GCC Application Ref: 21/00479/FUL

Address: 192 Kilmarnock Road Glasgow G41 3PG

PROPOSAL: Use of beauty parlour (Class 2) as cafe (Class 3) external alterations and use of public footpath as external seating area.

Invalid Application Acknowledgement

client			
MR J AITKEN			
project			
192 Kilmarnock Road, Glasgow, G41 3PG			
drawing			
Proposed Plans			
project number	scale		
201919005	1:50	@A3	
drawing number	rev	issue status	
AL(0)03	A	PLANNING/WARRANT

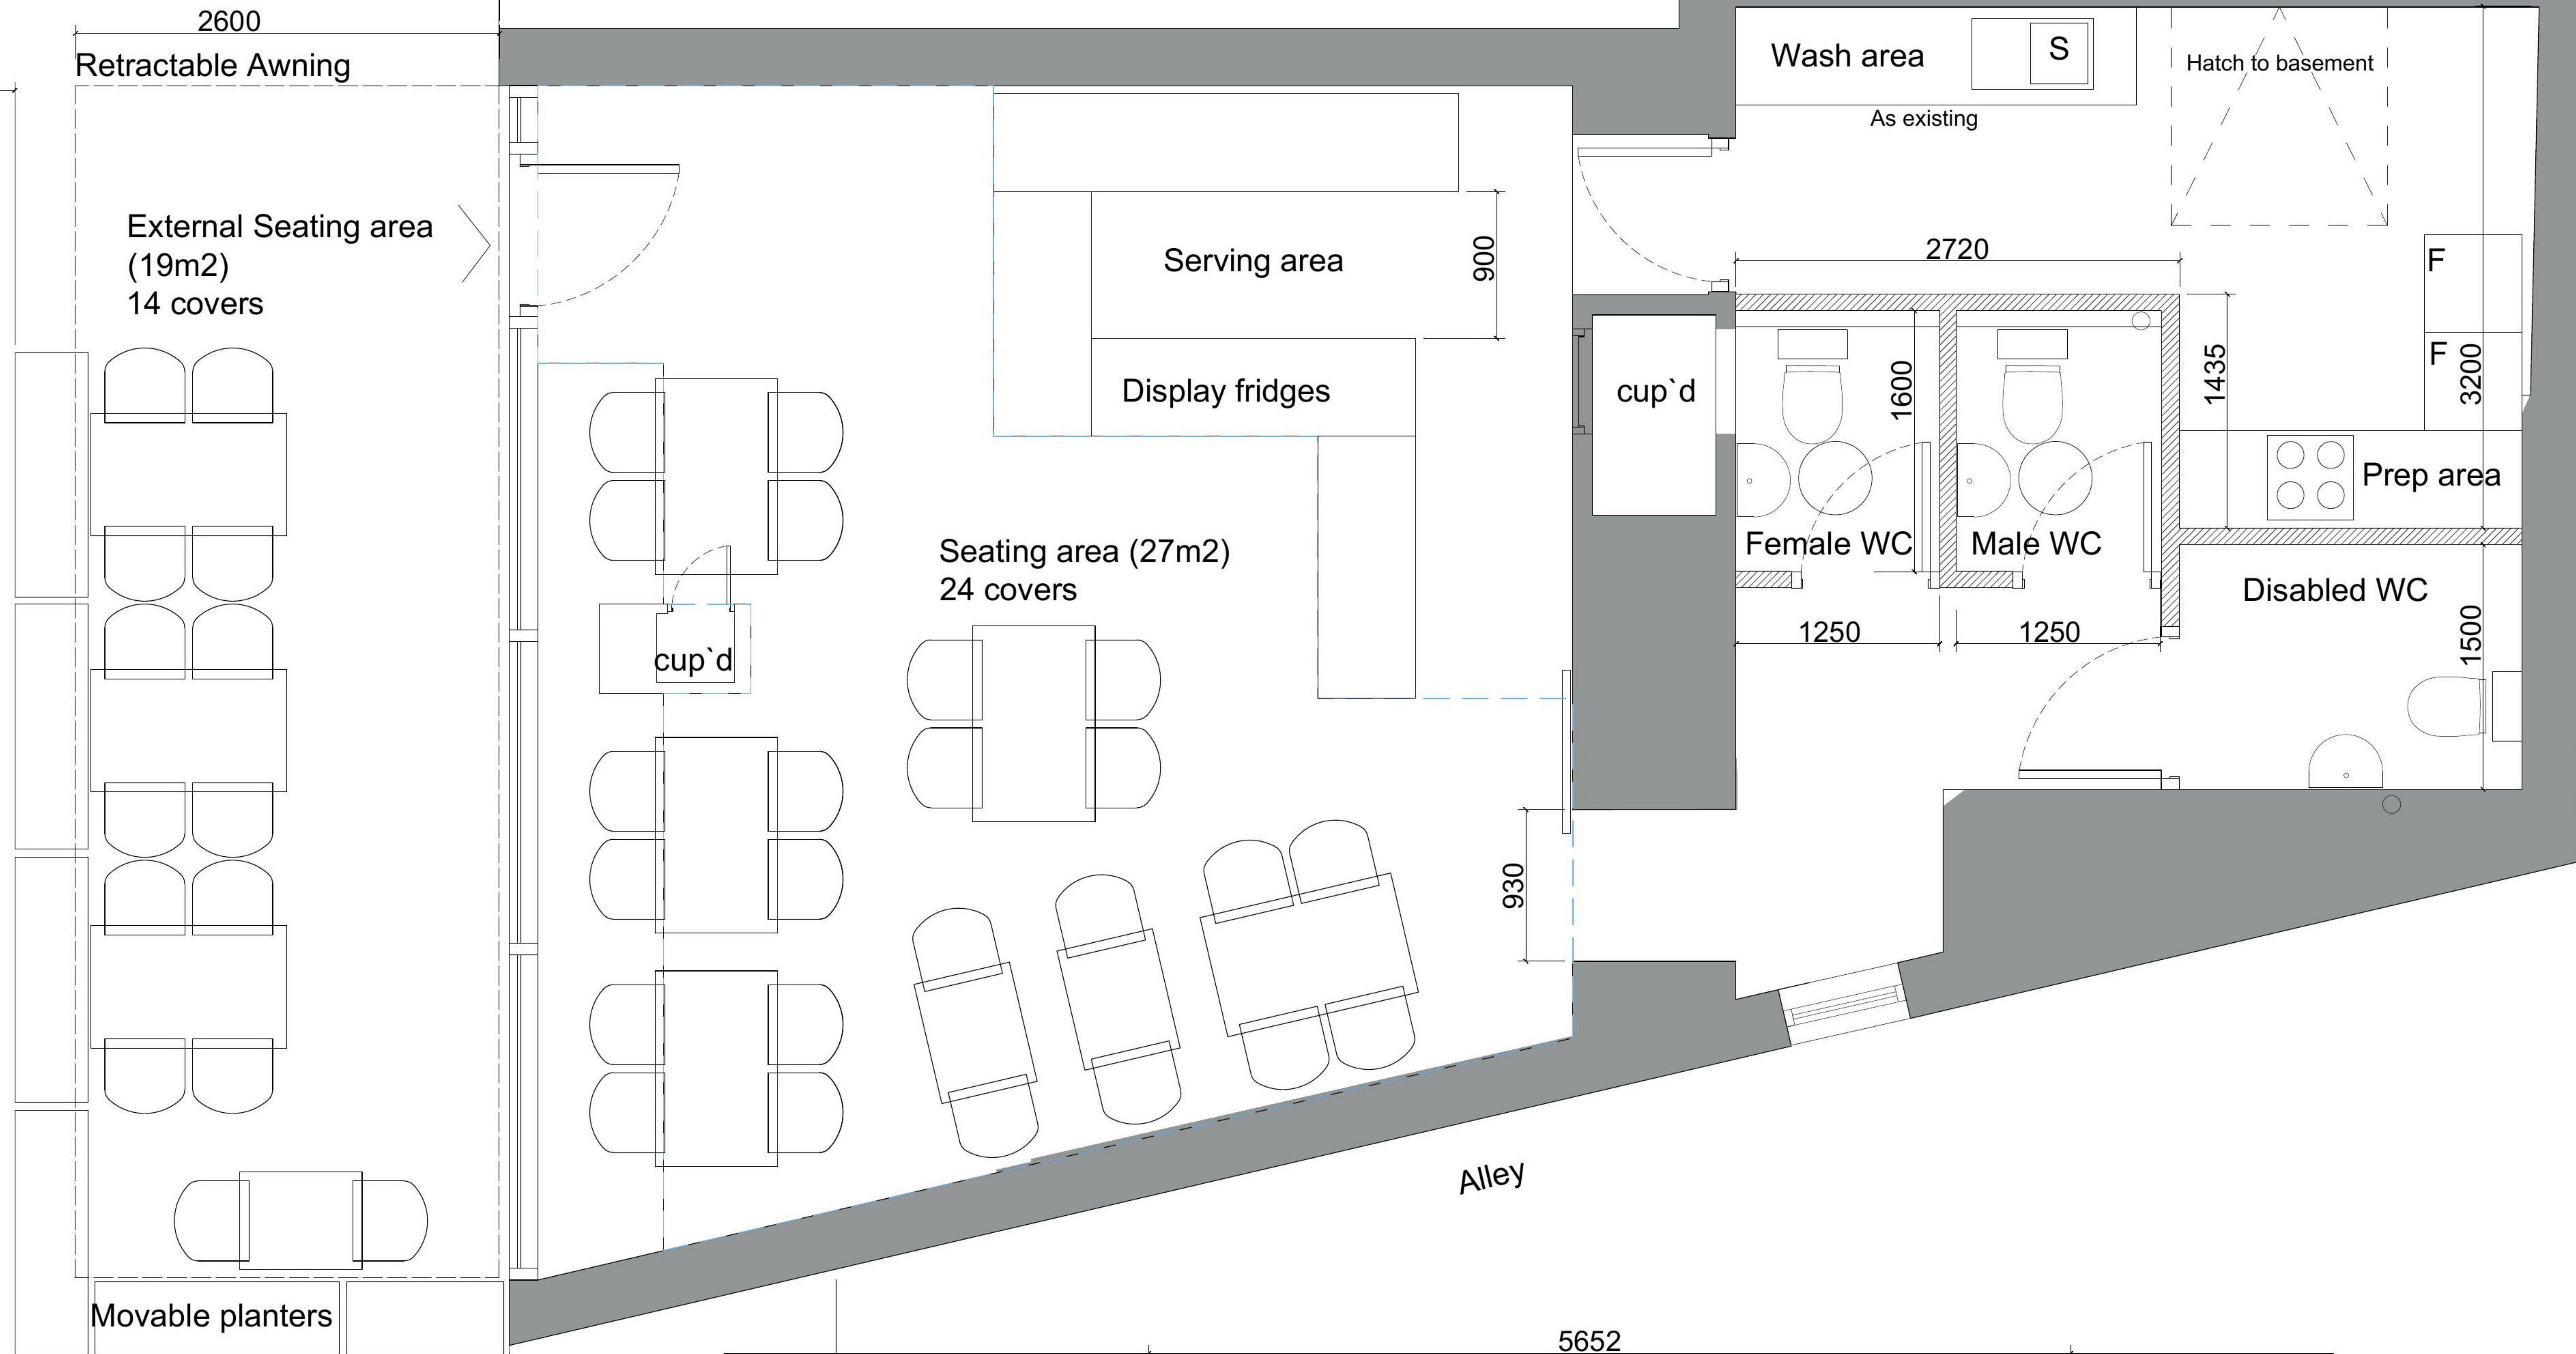
003 Please amend the title at the proposed elevation drawing from "Existing" to "Proposed"

Please find attached updated layout AL(0)03 Rev A

client		
MR J AITKEN		
project		
192 Kilmarnock Road, Glasgow, G41 3PG		
drawing		
LOCATION PLAN		
project number	scale	
201919005	1:500	@A3
drawing number	rev	issue status
AL(0)01	A	PLANNING/WARRANT

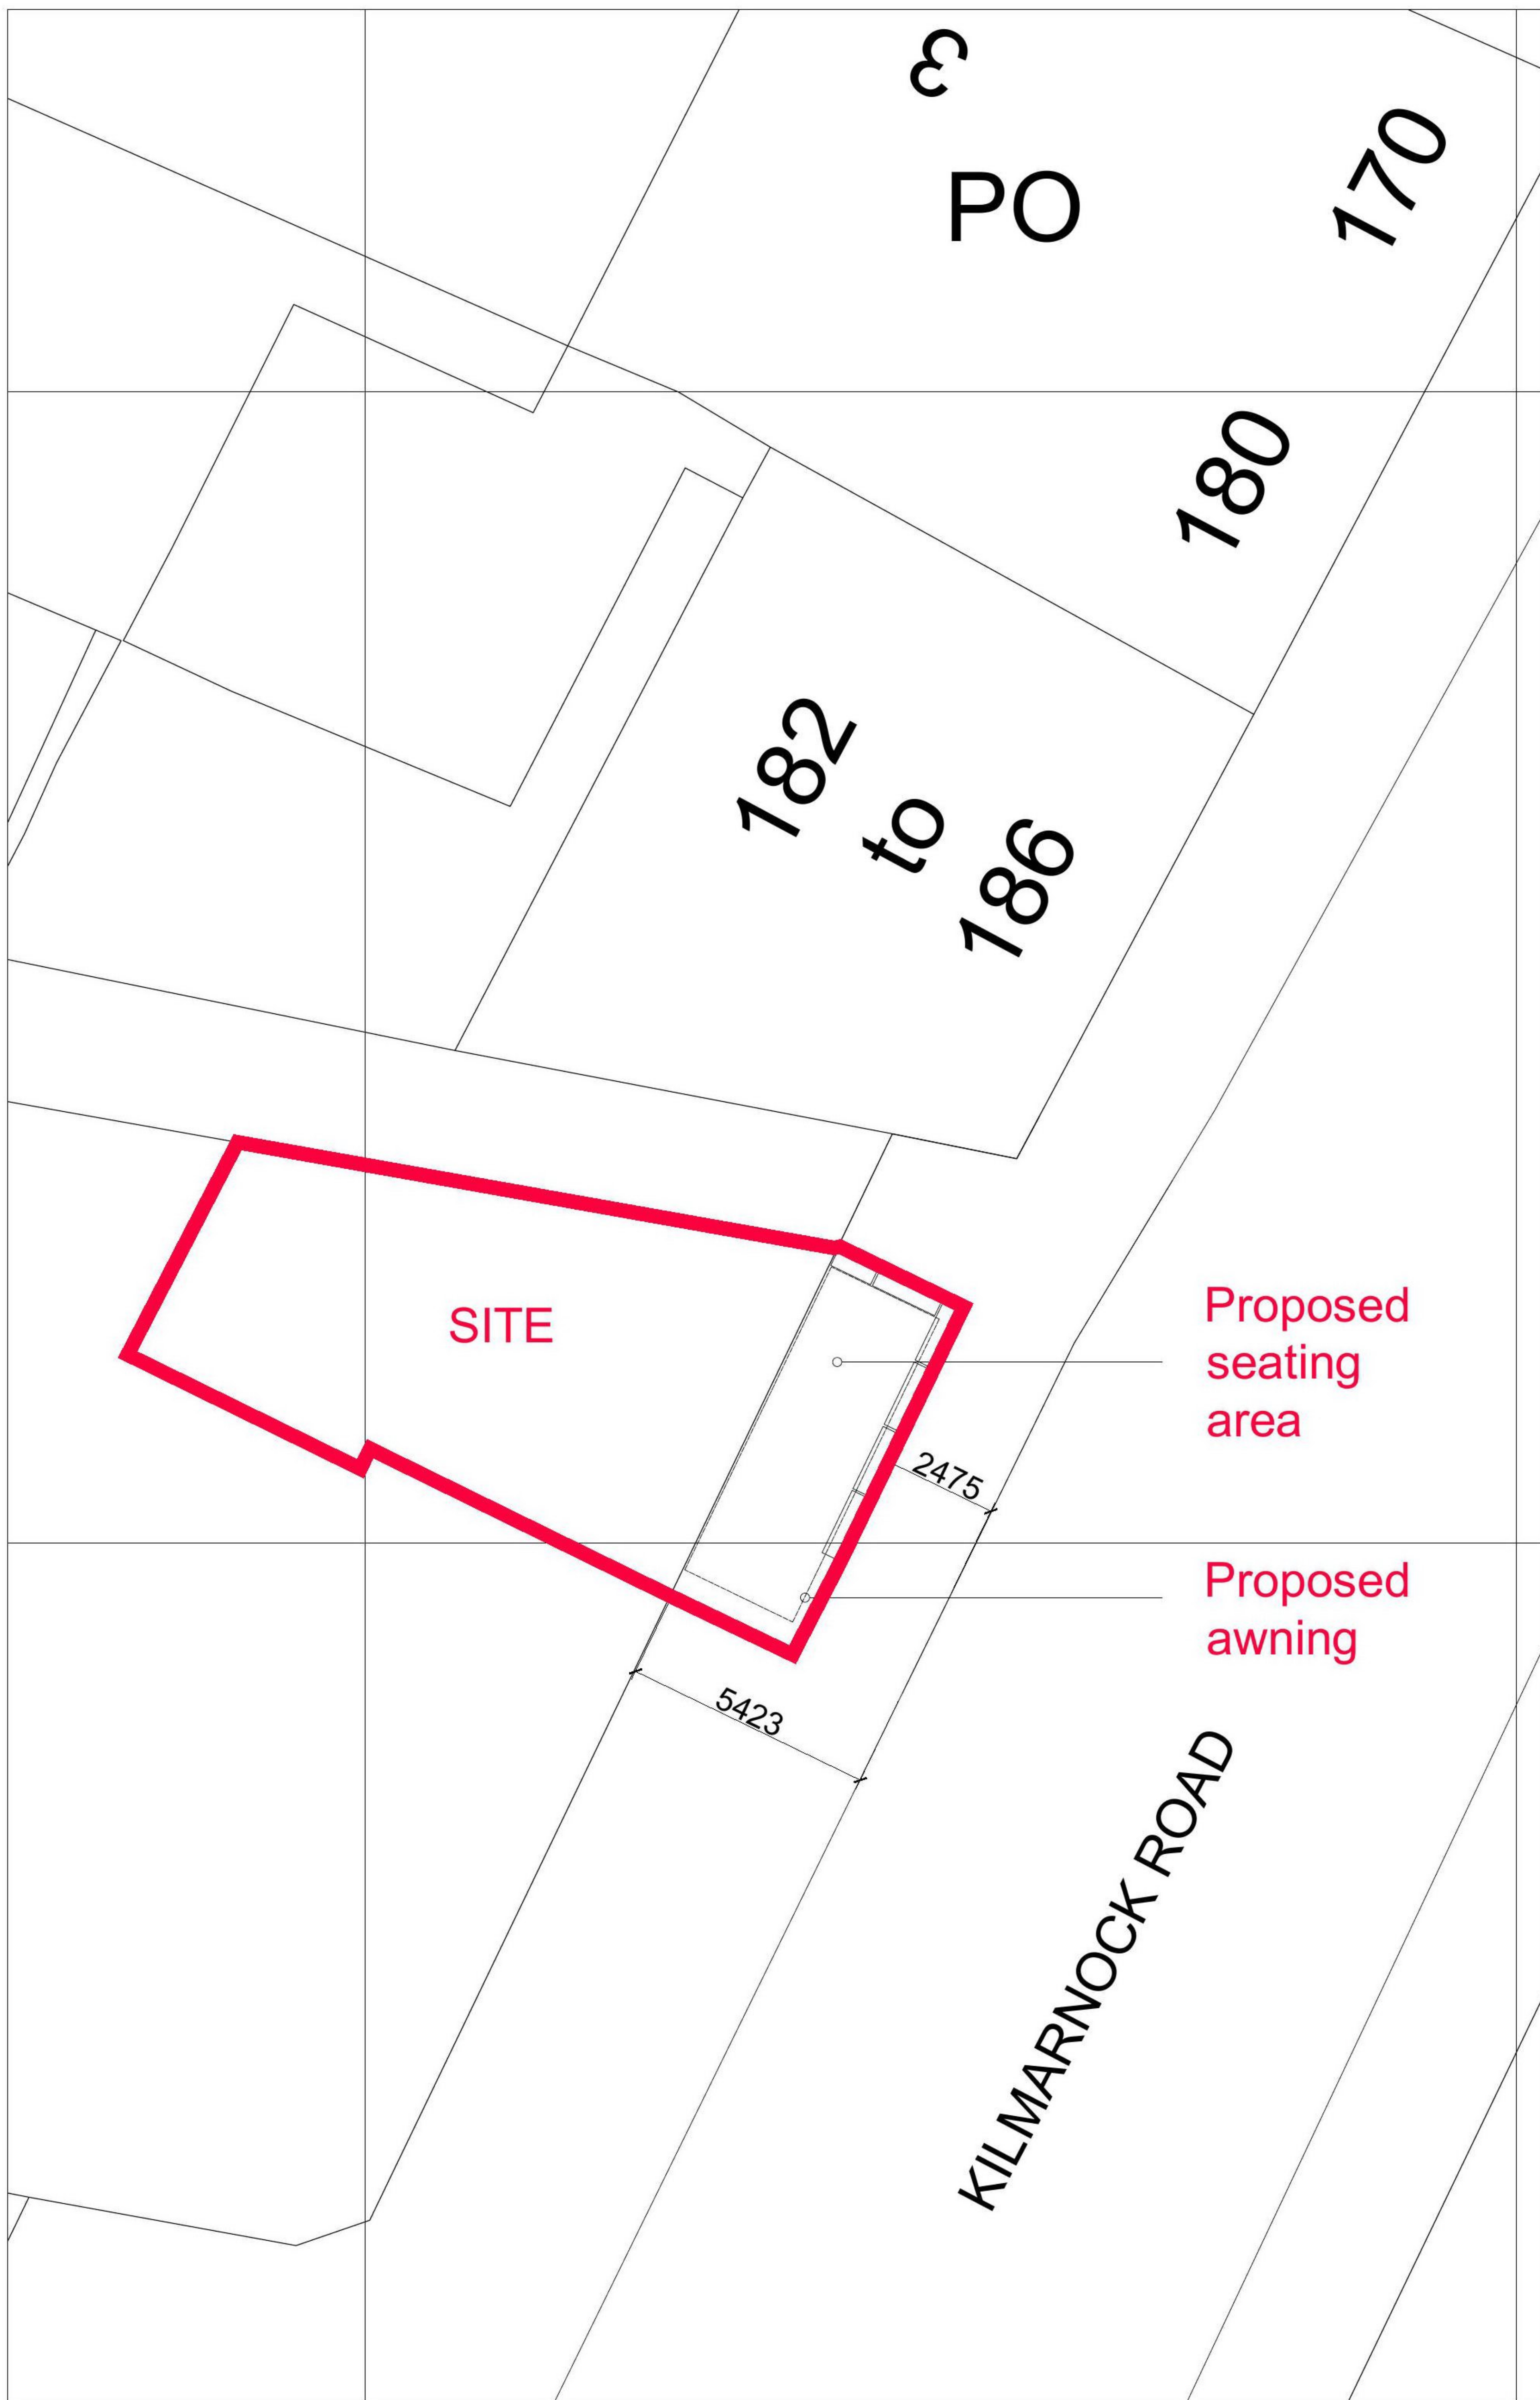
001 The submitted location plan does not identify the area of public footway covered by the application. Please revise the application site boundary by extending the red line to include the area covered by the proposed seating. This is to allow neighbour notification to be accurately carried out.

Please find attached updated location plan. L(0)01 A.
